From: Peter Jenkins [REDACTED]
Sent: 22 July 2021 14:43
To: Planning <Planning@arun.gov.uk>
Subject: M/91/21 planning.

As frequent users of Elmer Beach we were surprised to see the extent, proximity and height of this development. It is very prominent and completely out of character and size to existing buildings and we consider it will both diminish the nature of this area and also be utilised as evidence for similar future developments, a proliferation of which would be very detrimental.

PROJECT	27 Central Drive - Elmer Beach	DATE	16/09/18
TITLE	Proposed South Elevation	DRG NO	IBA/507/05
SCALE	1 : 50	REVISIONS	B

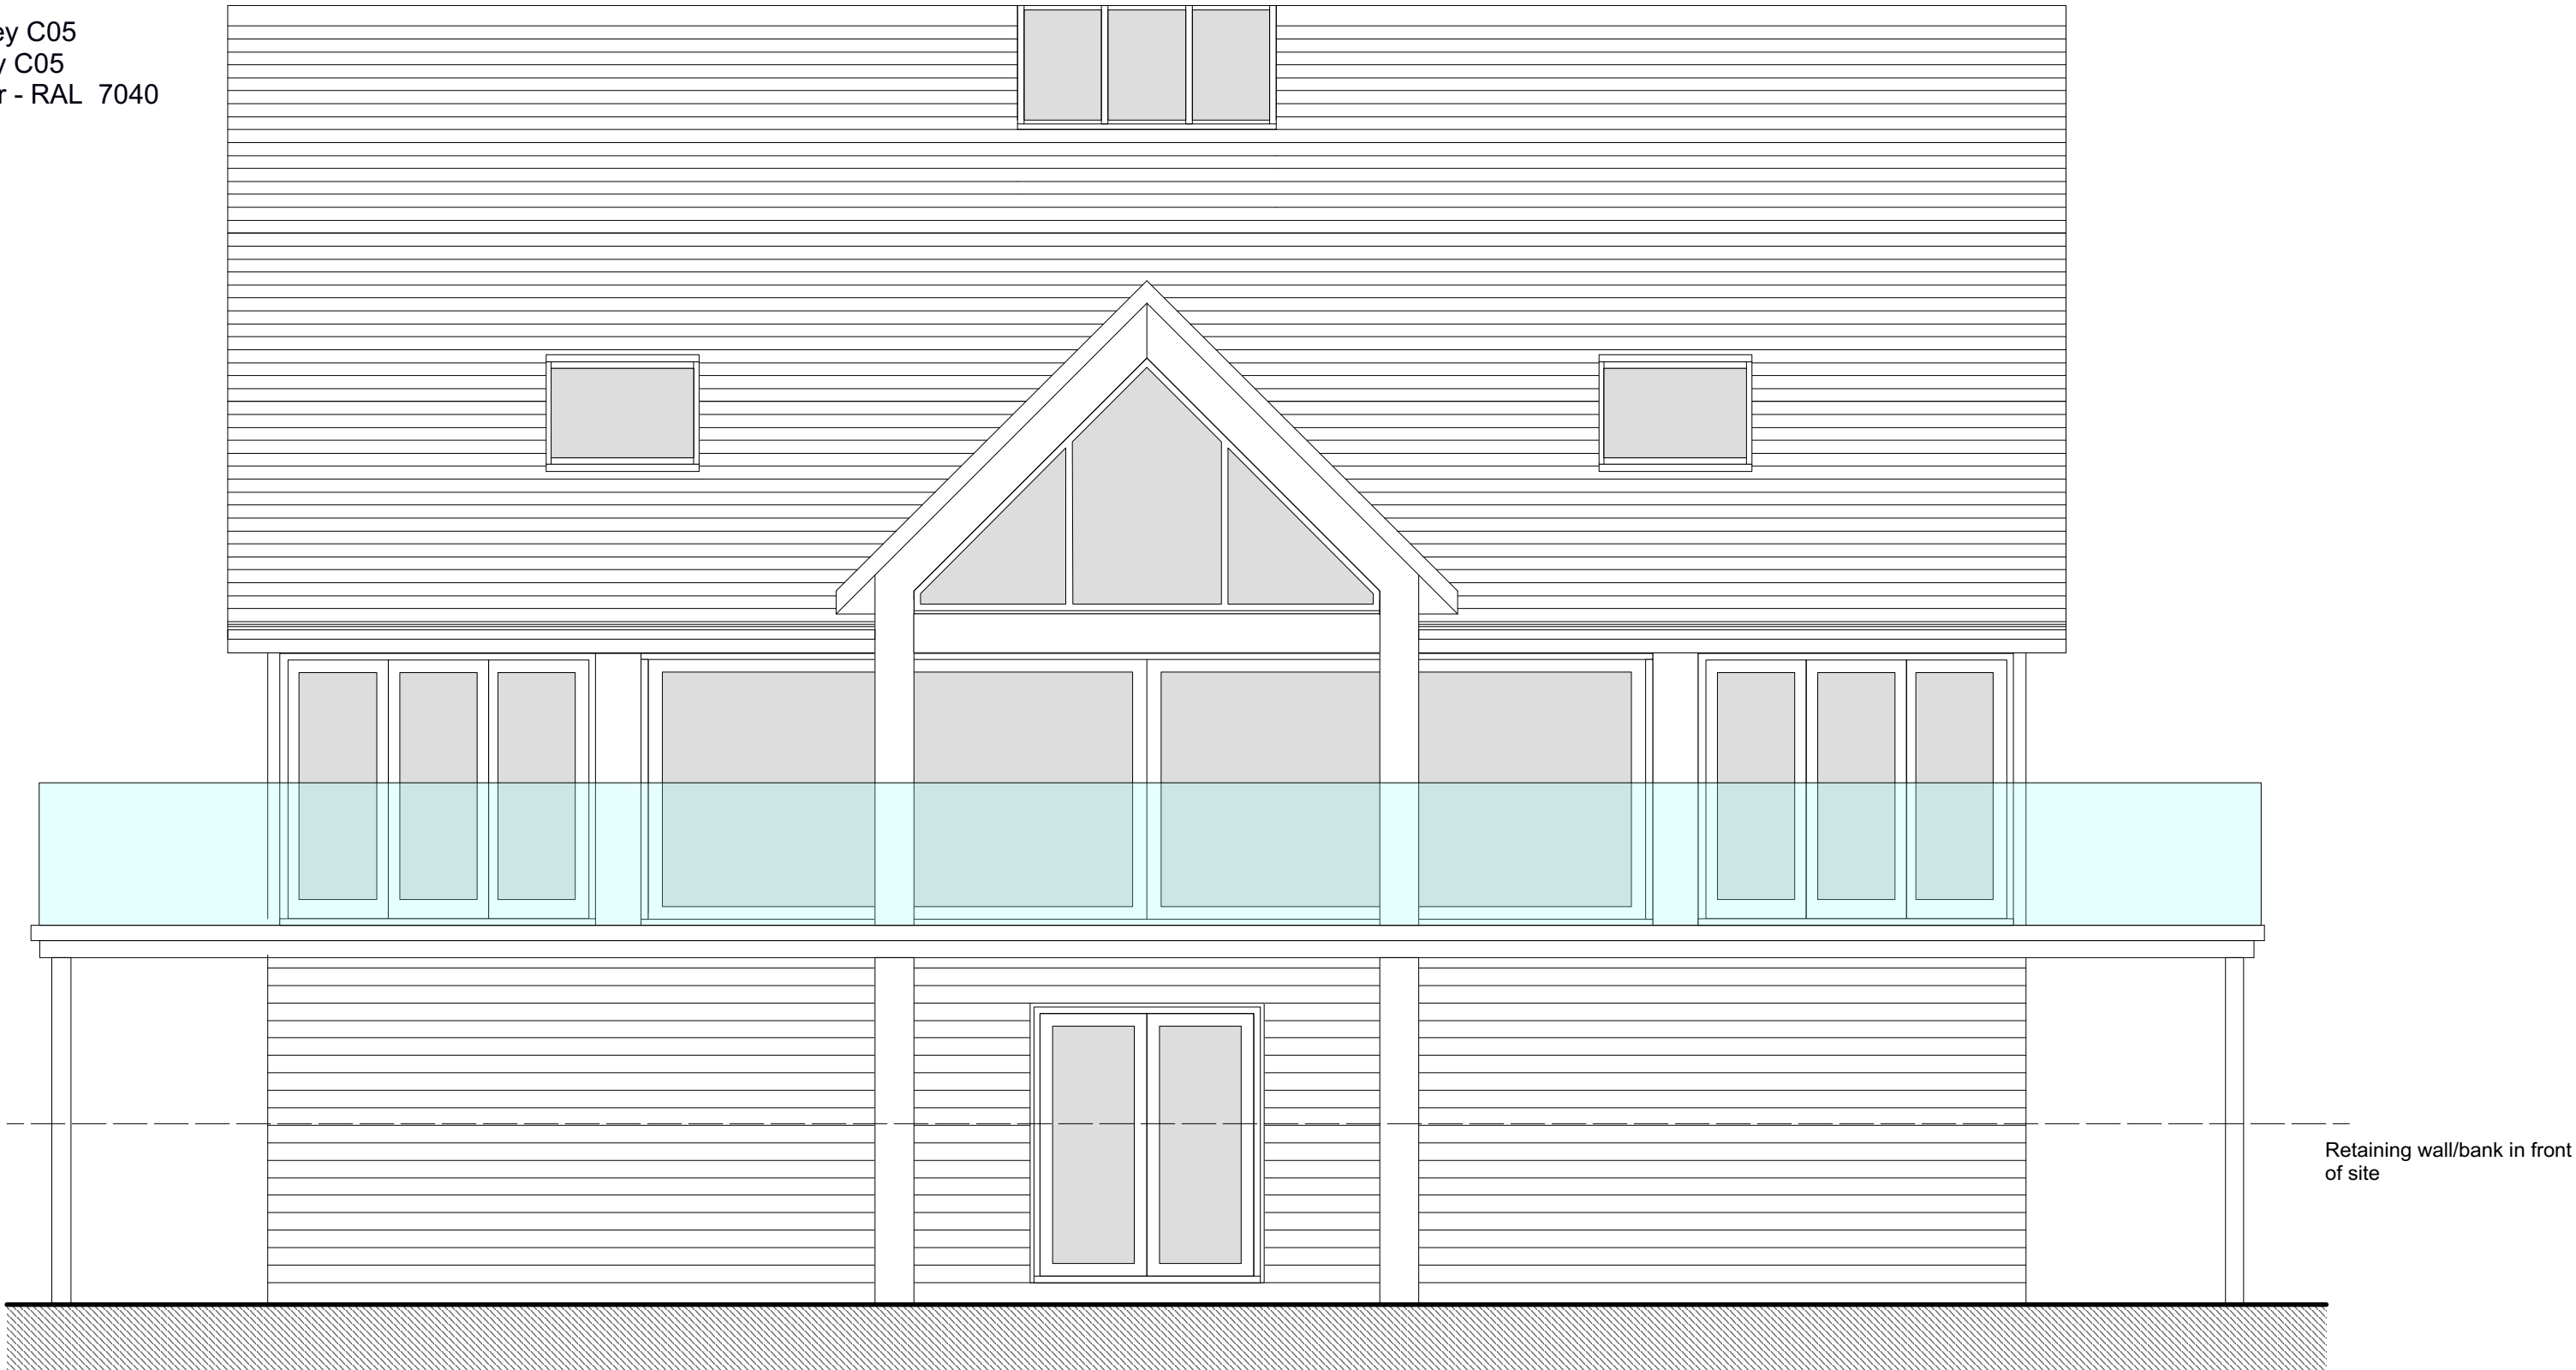
We understand, possibly erroneously, that the drawings submitted were not to scale and represented the height as being equivalent to the neighbouring house which is clearly not the case, as such, if true, is a misrepresentation and should disqualify the planning consent to deter others from similar tactics.
